MORGAN AND MORECAMBE OFFSHORE WIND FARMS: TRANSMISSION ASSETS

Applicants' Response to Deadline 5 submissions from Statutory Consultees and other organisations

Document Reference: S_D6_2
F01

22 October 2025

Figure 1.19a: Undefended 1% AEP joint probability event plus 20% climate change uplift event

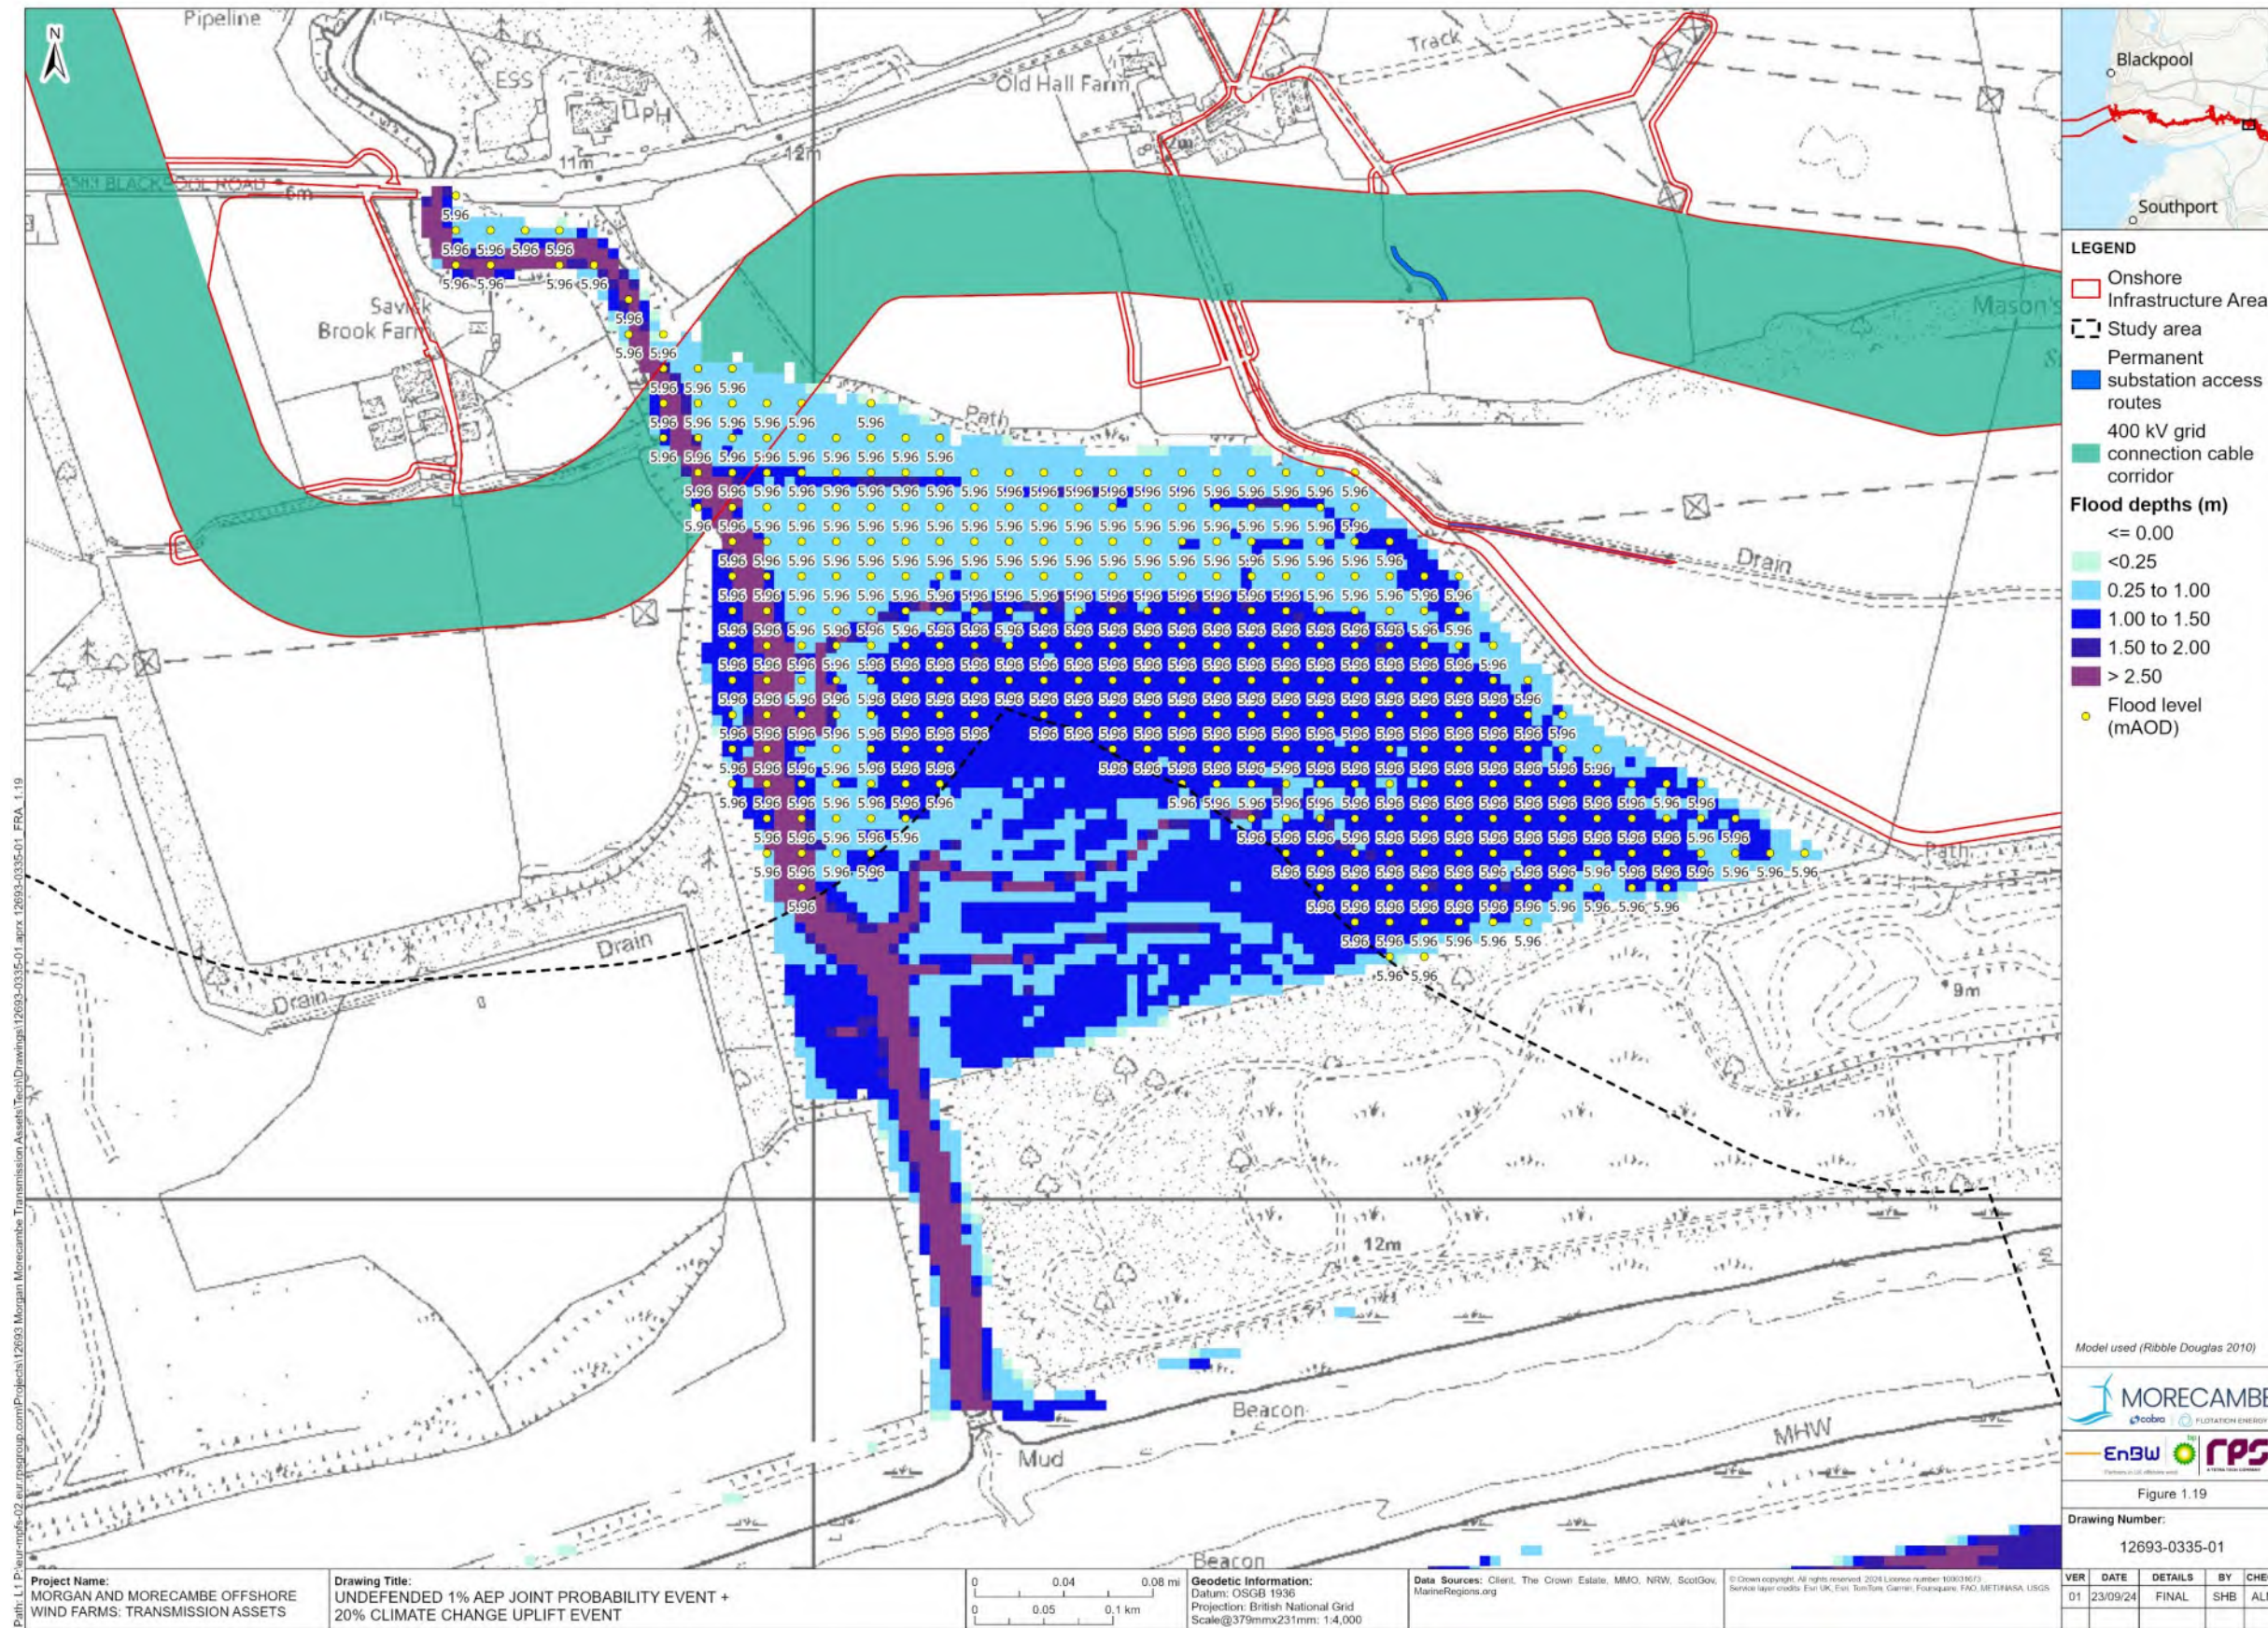
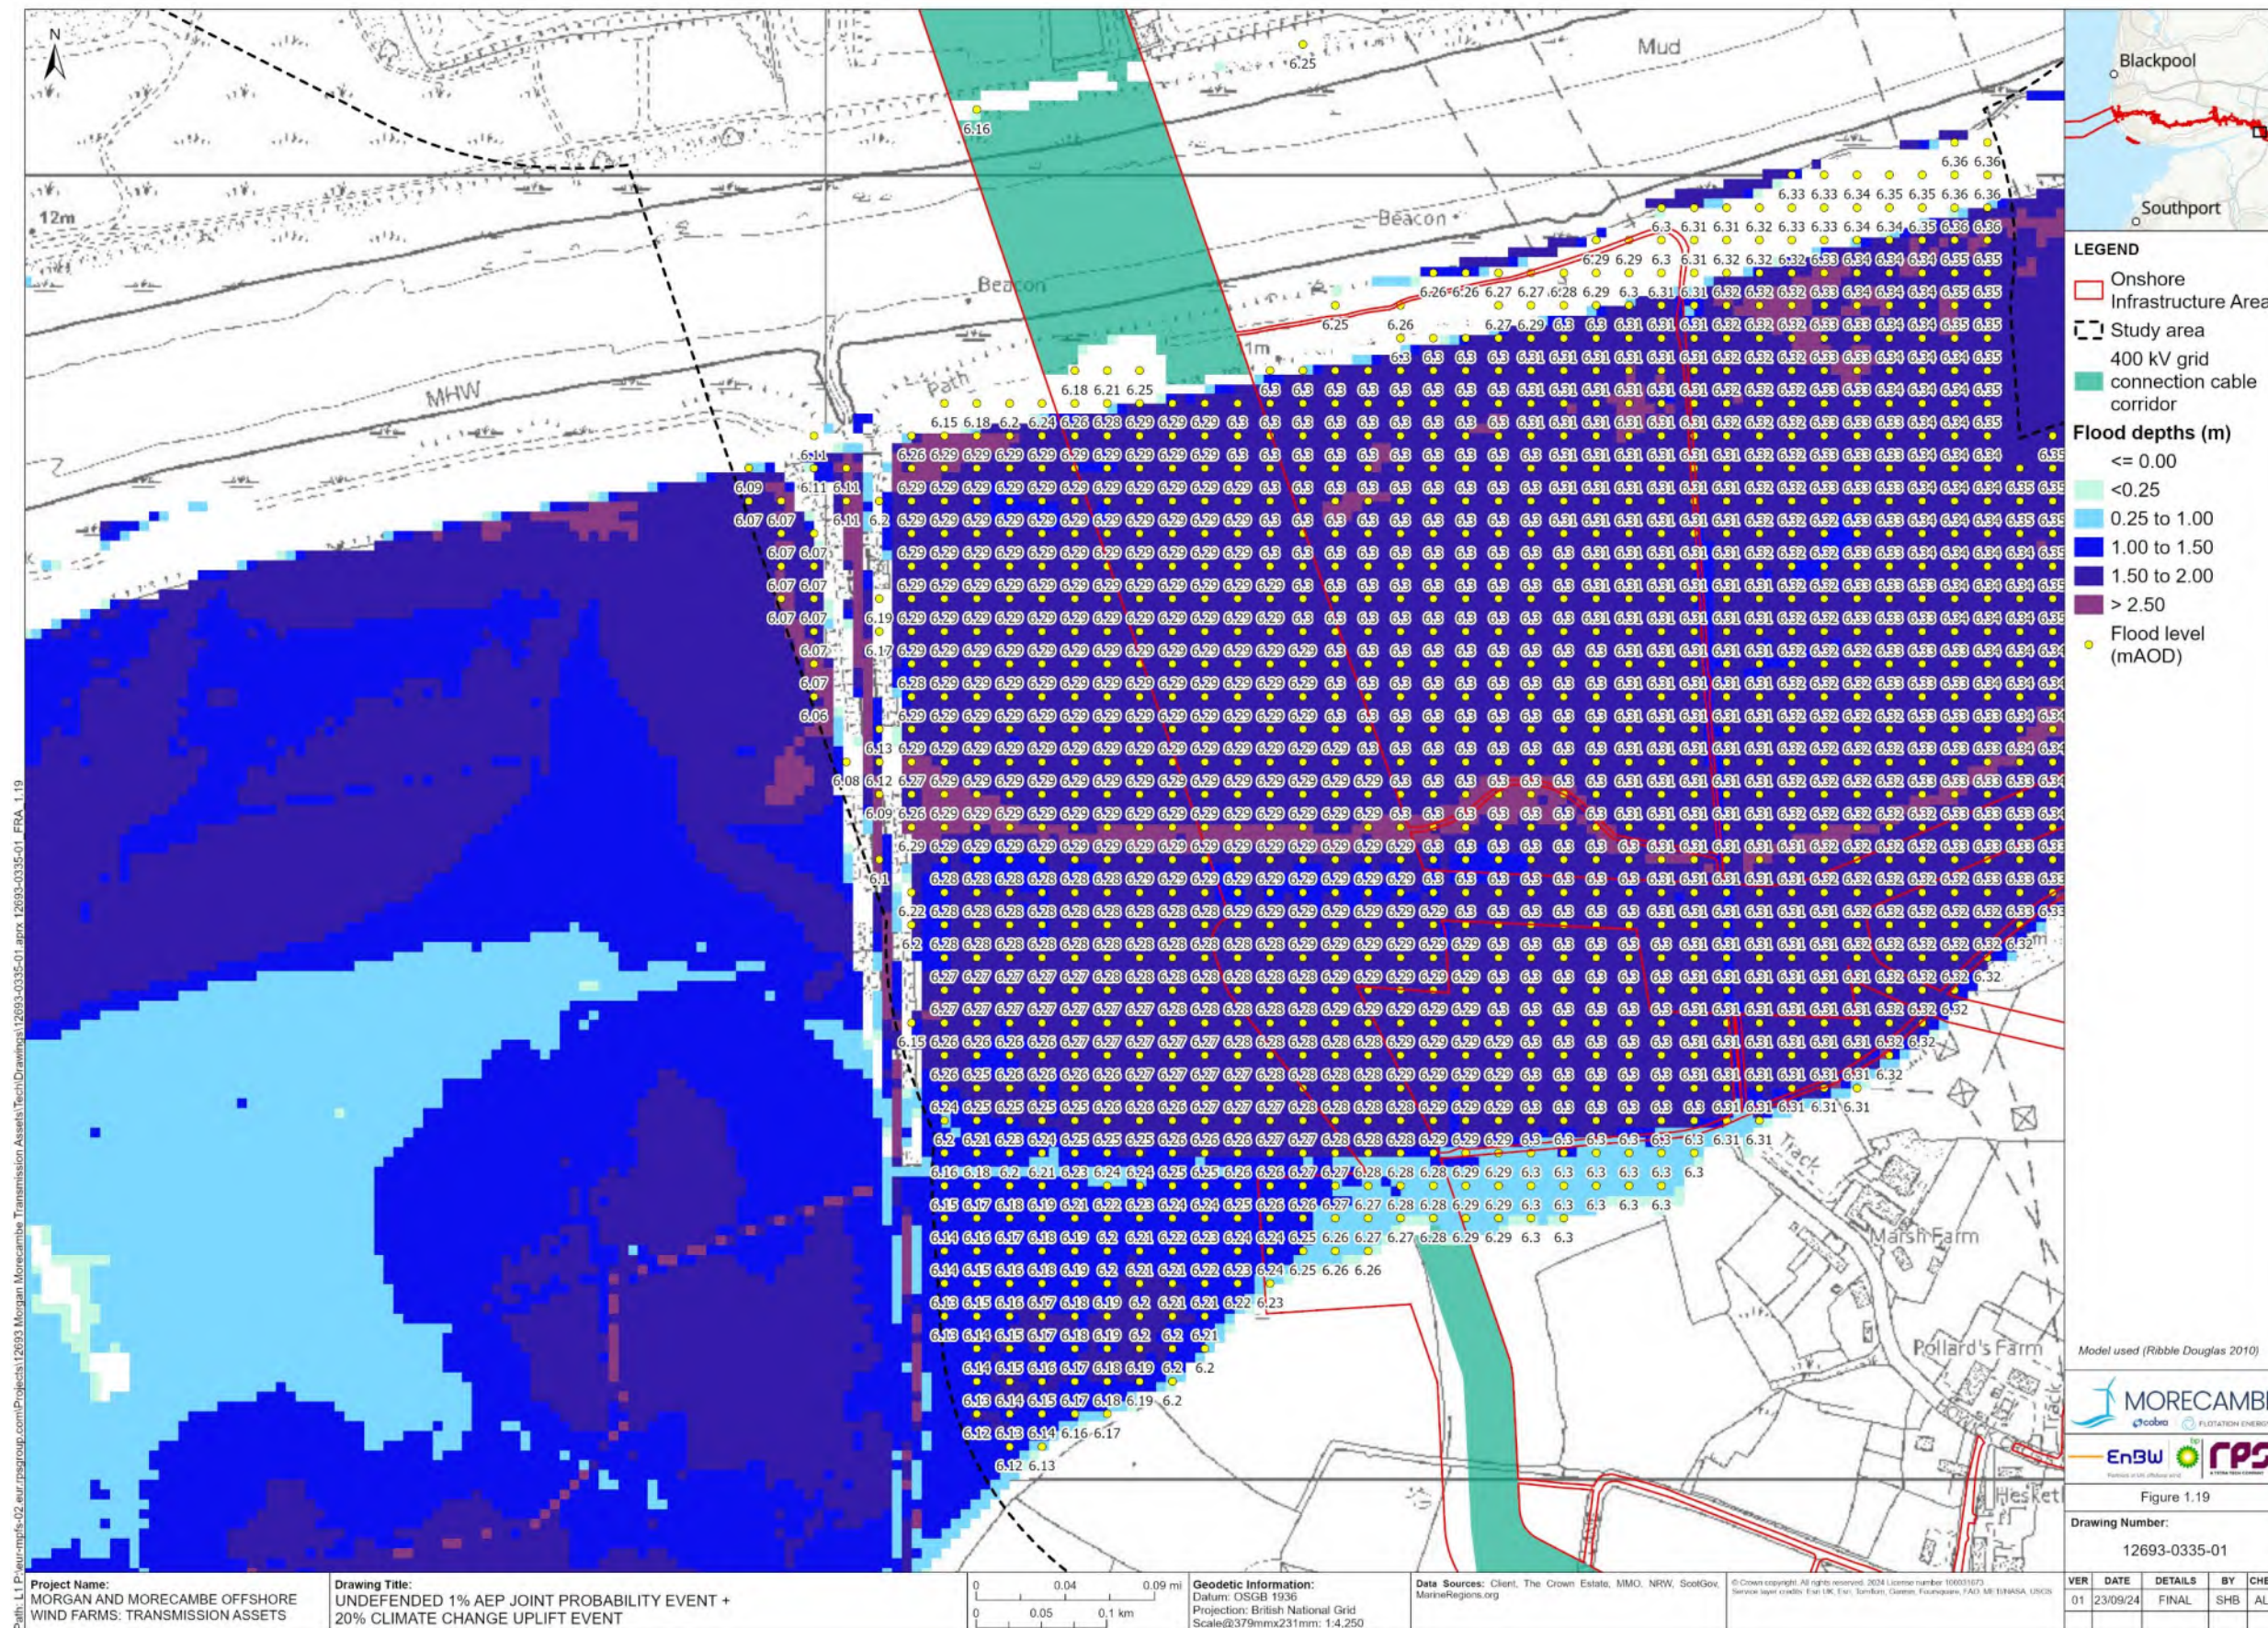
REP5-168	<p>Volume 3, Annex 2.3: Flood risk assessment - part 2</p>	<p>The Applicants note this comment and confirm that the discrepancy only appeared on the tracked version and therefore, no changes were required. The</p>

Reference	IP submission	Applicants' response
168.9	<p>Pages 163- 166</p> <p>Issue: Changing in titles and figure numbers appears to have resulted in a discrepancy between the new figure label in the report and the figure reference in the original title box of the drawing.</p> <p>Impact: This makes references somewhat problematic and confusing.</p> <p>Solution: Clerical error requiring correction</p>	<p>Applicants have ensured that all figure references and numbers are consistent. An updated version of volume 3, Annex 2.3: Flood risk assessment (F3.2.3/F03) has been submitted at Deadline 6.</p>
REP5-168 168.10	<p>Volume 3, Annex 2.3: Flood risk assessment part 3</p> <p>Issue: Like previous comments.</p> <p>Changing in titles and figure numbers appears to have resulted in a discrepancy between the new figure label in the report and the figure reference in the original title box of the drawing.</p> <p>e.g. Figure 1.23: Undefended 1% AEP fluvial event plus 20% climate change uplift on Page 199 is figure 1.17 in the drawing title box.</p> <p>Impact: This makes referencing somewhat problematic and confusing.</p> <p>Solution: Clerical error requiring correction</p>	<p>The Applicants note this comment and have updated all figure references and numbers where appropriate. An updated version of volume 3, Annex 2.3: Flood risk assessment (F3.2.3/F03) has been submitted at Deadline 6.</p>
